PLANNING APPLICATIONS AND S106 OBLIGATIONS

Reference A. Planning Application 19/02550/F
B. Planning Obligations 21/03164/OBL

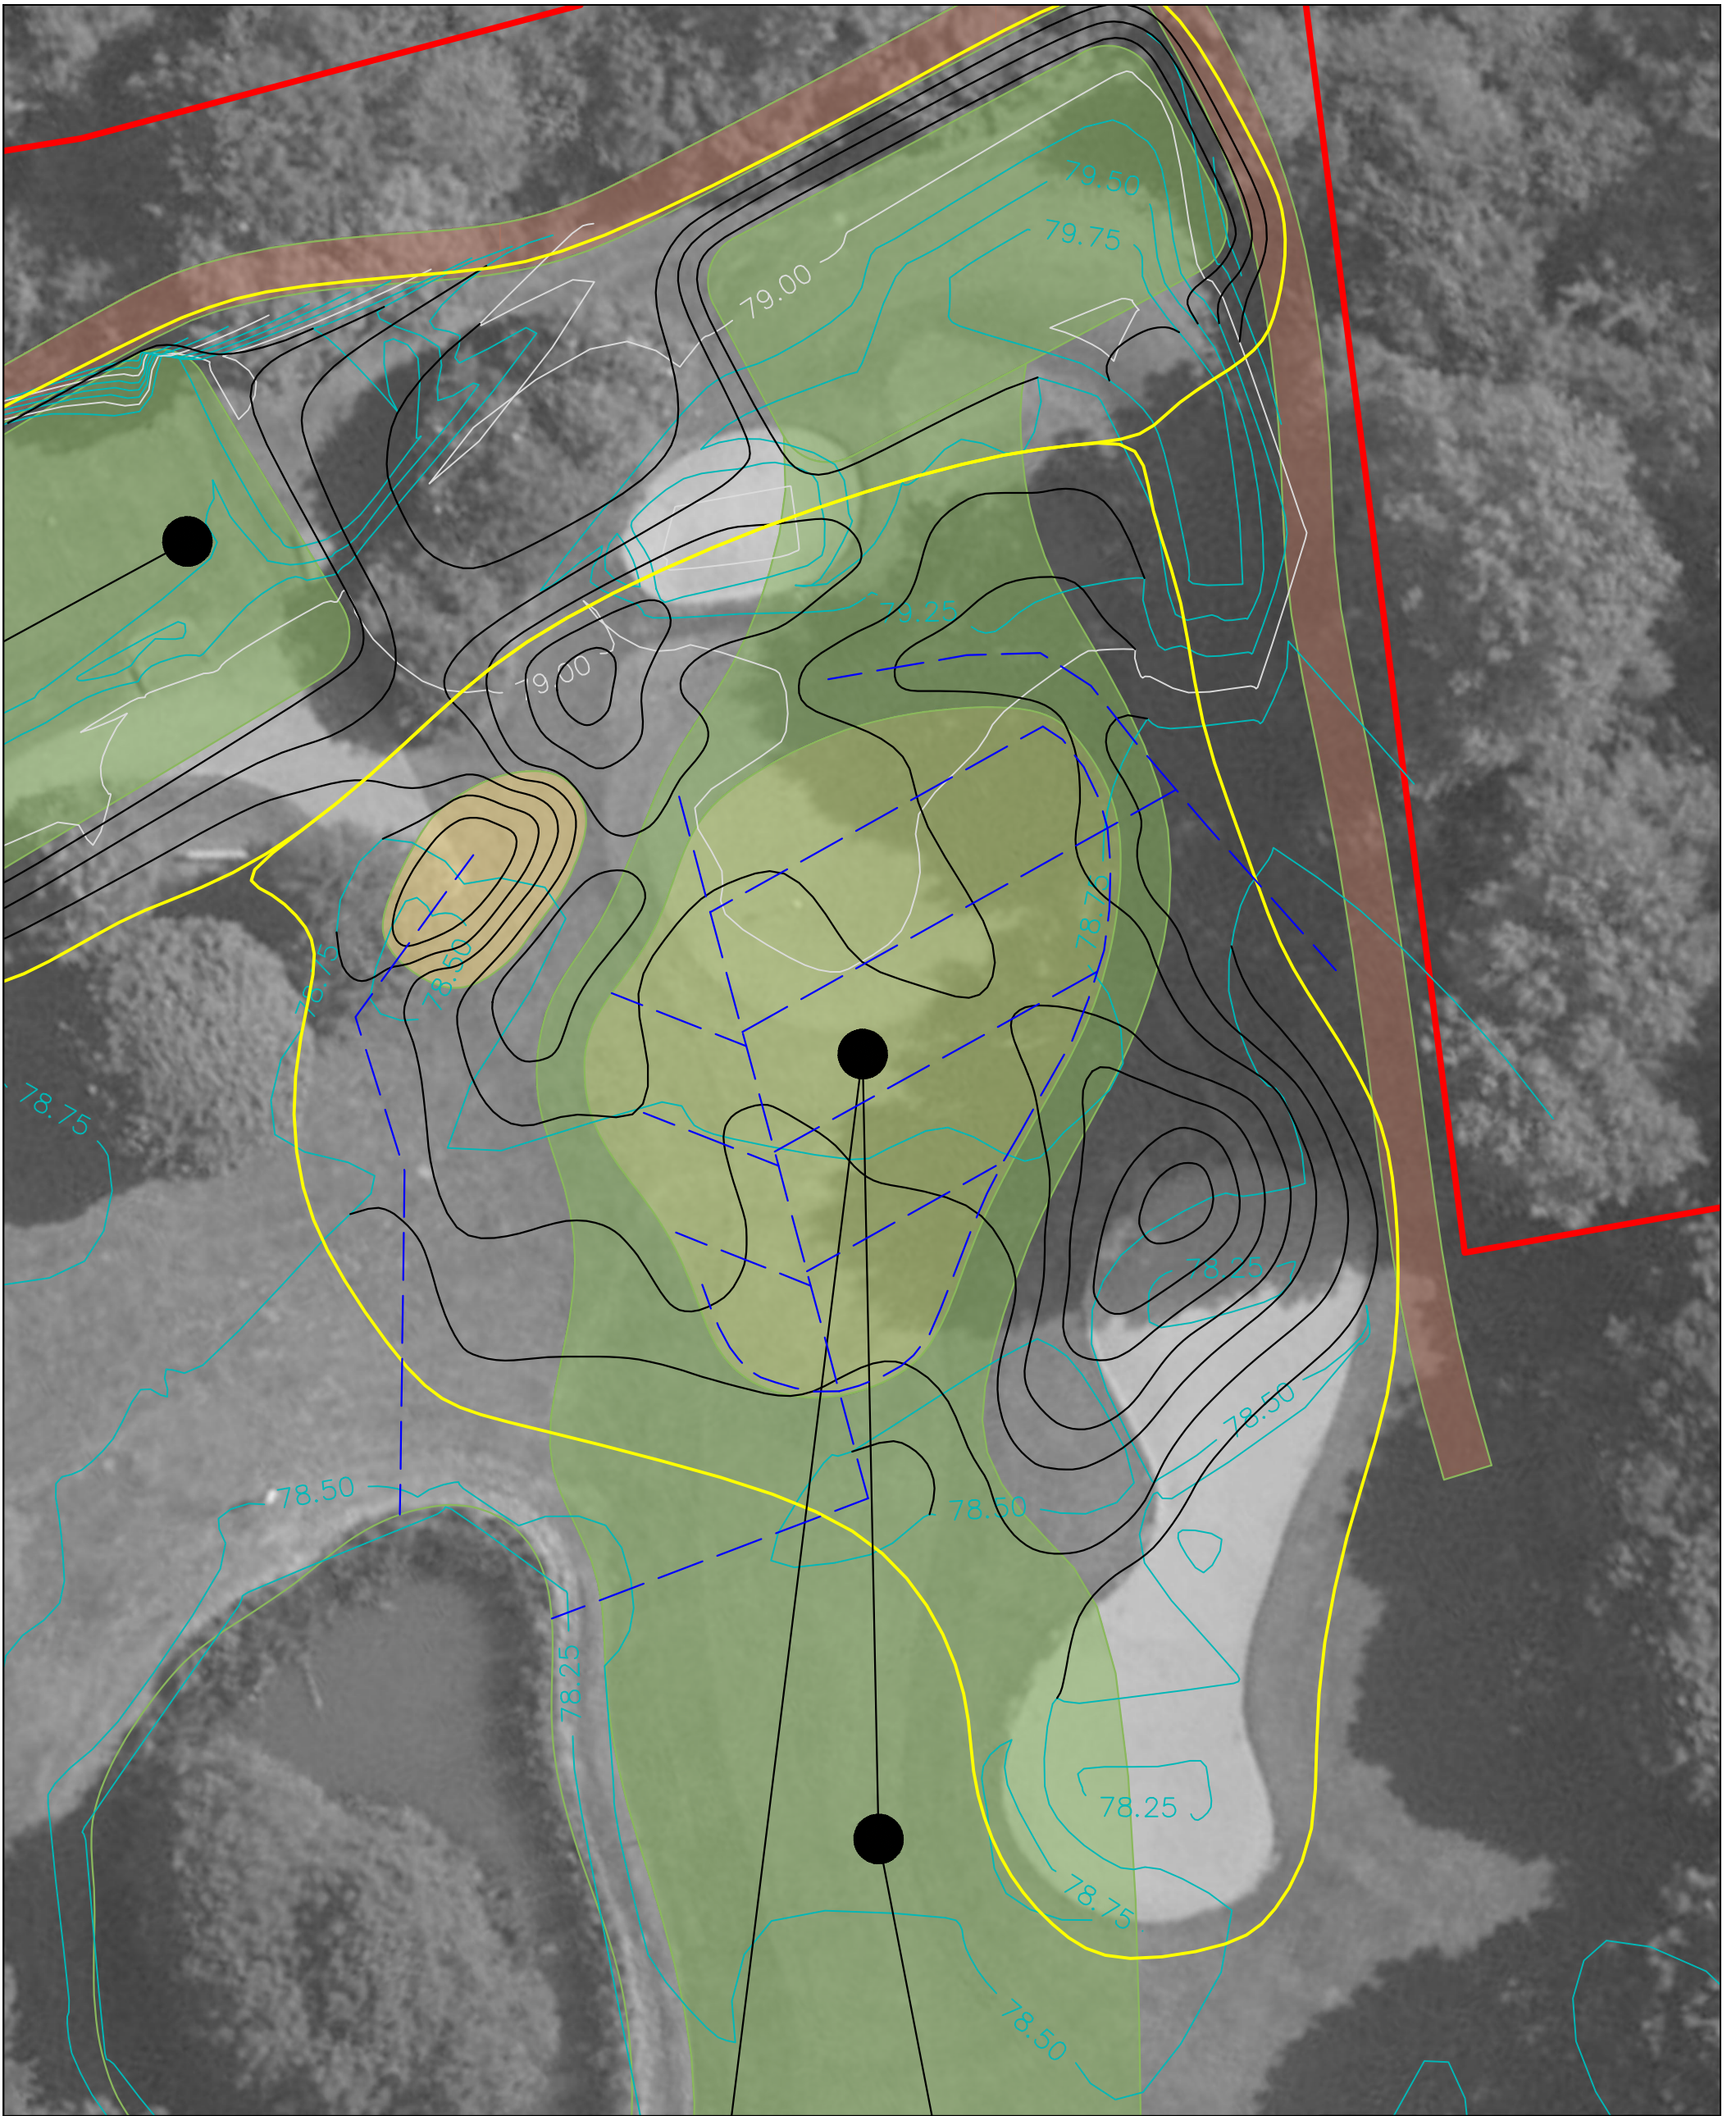
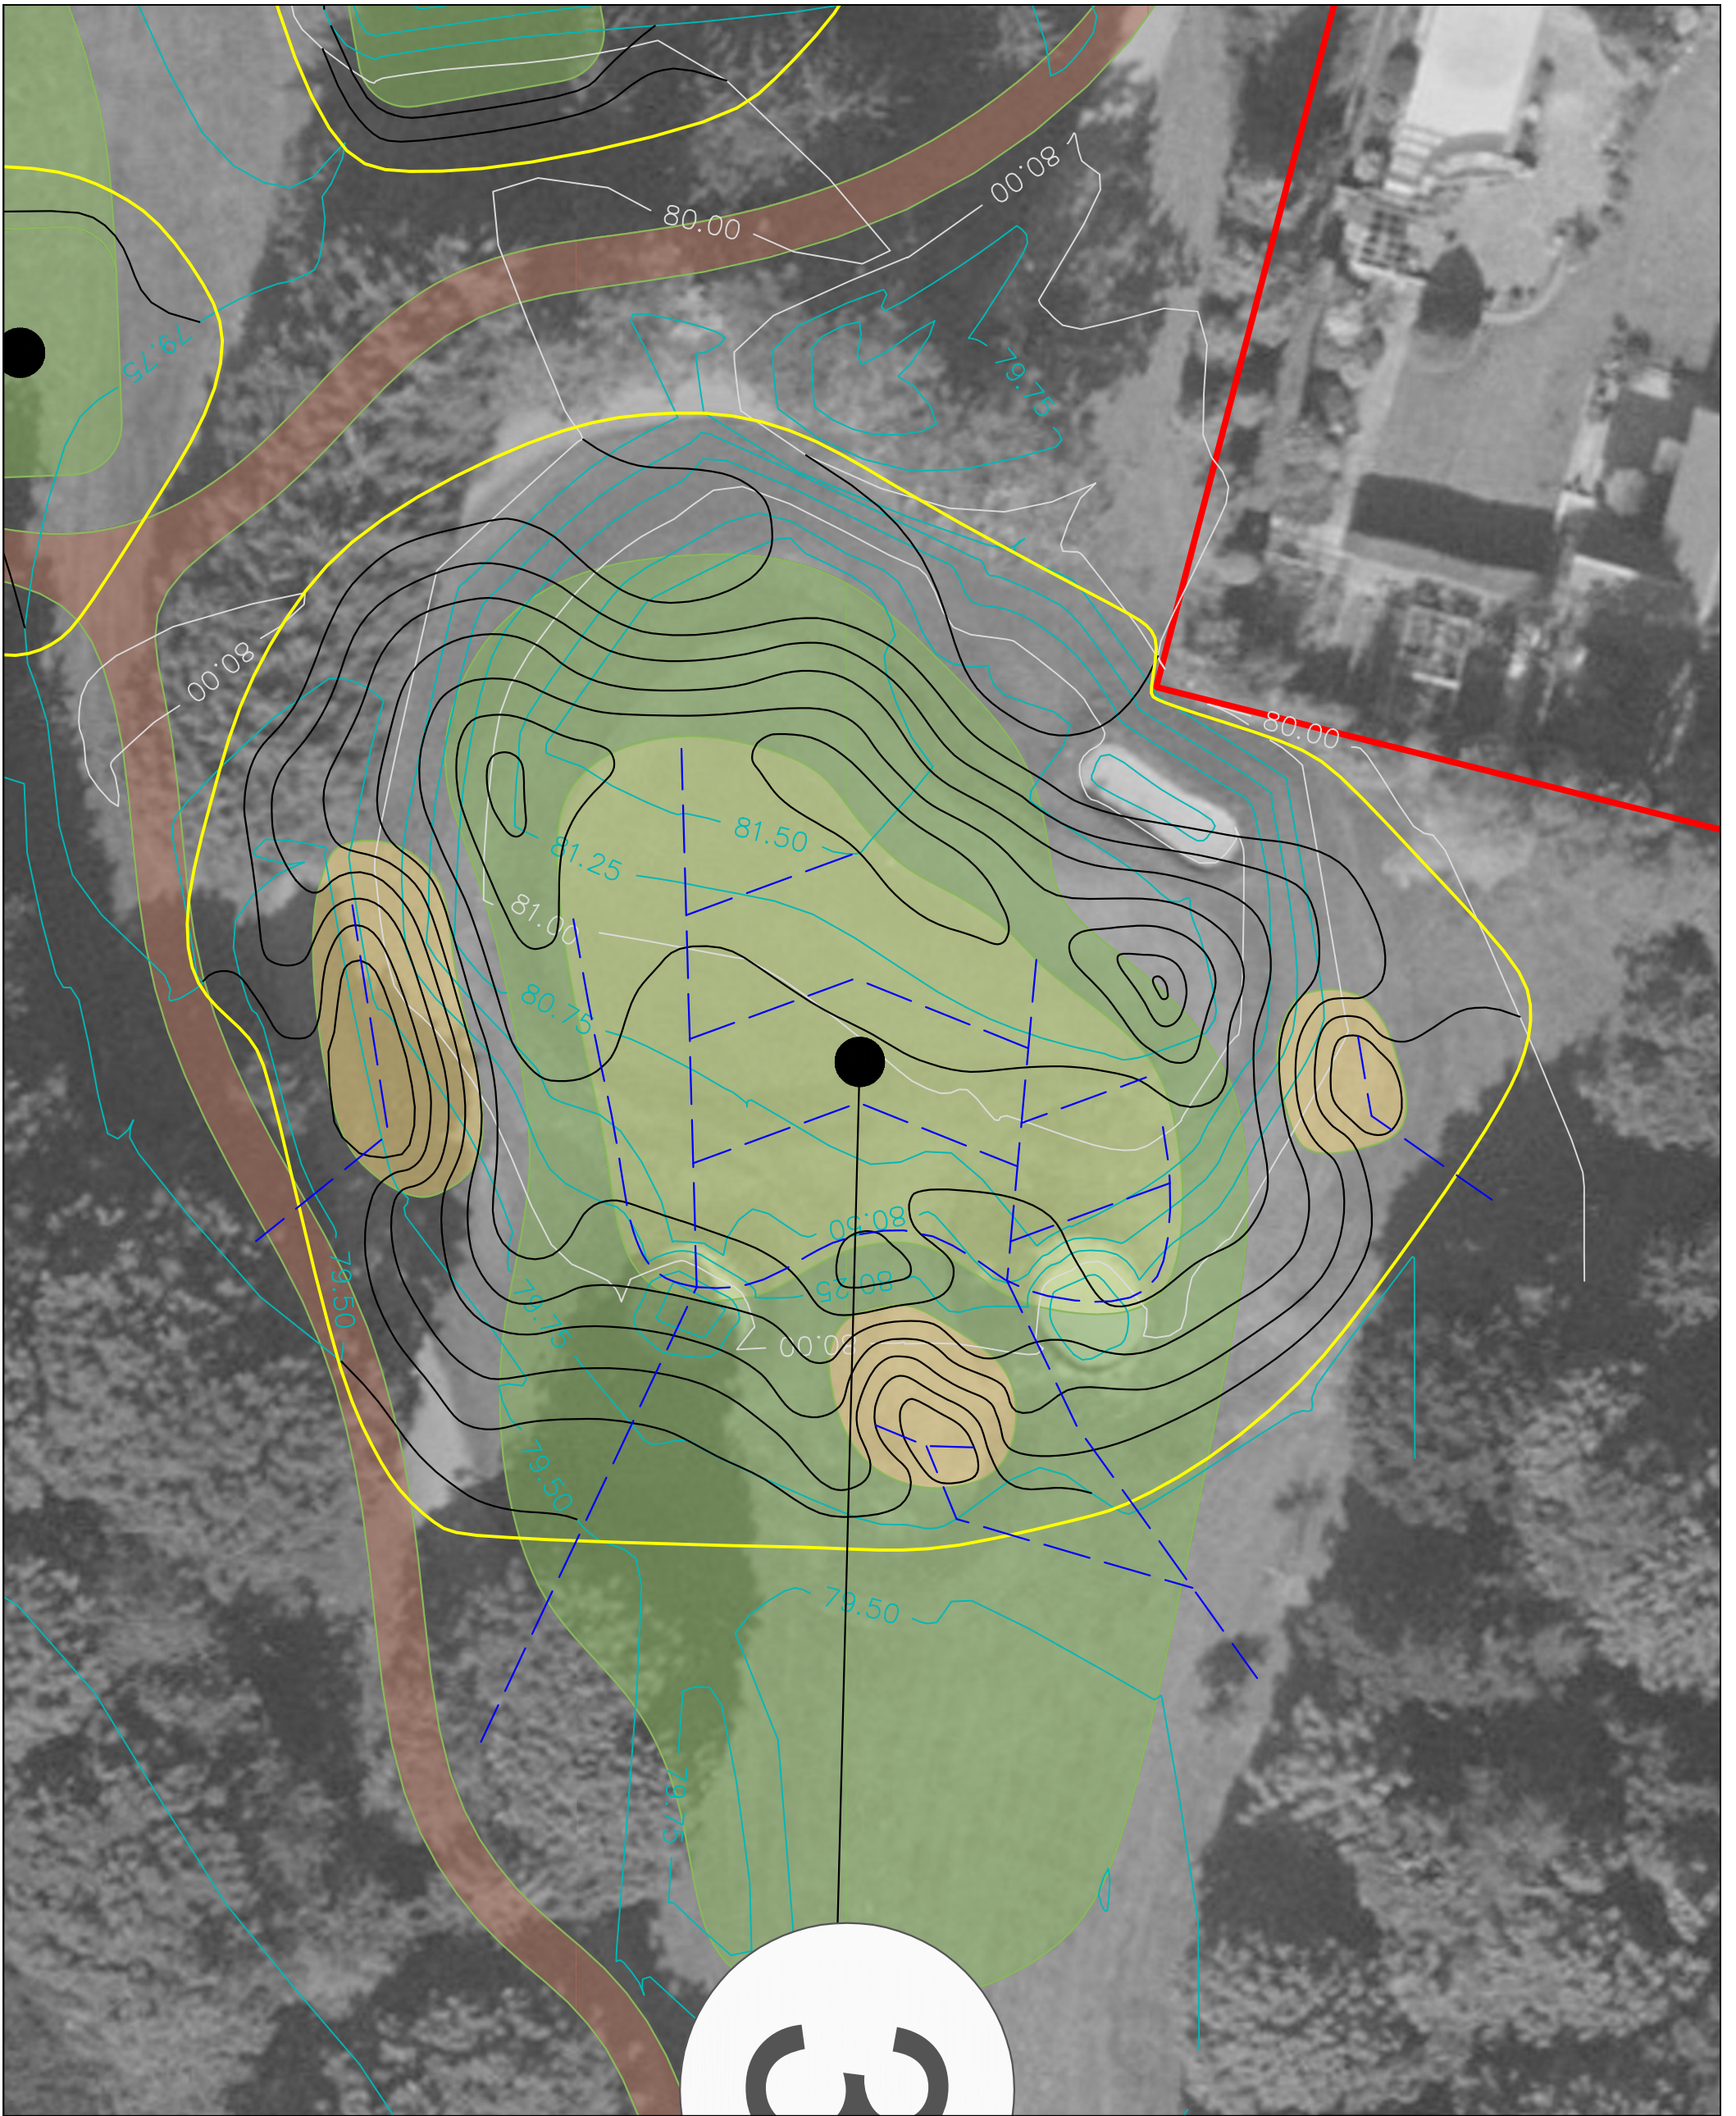
1. In particular they fail to properly address the matters of Health and Safety regarding the crossover points of golfers on the proposed new golf course layout. They do not provide any plan for the holes 10 to 18 where conflict when playing different circuits occurs. The only course plan provided is for holes 1 to 6. It seems their plan has not been submitted to Golf England for over-site and approval, yet the designer say it's an improved golfing facility. This is insufficient information for discharge to proceed.
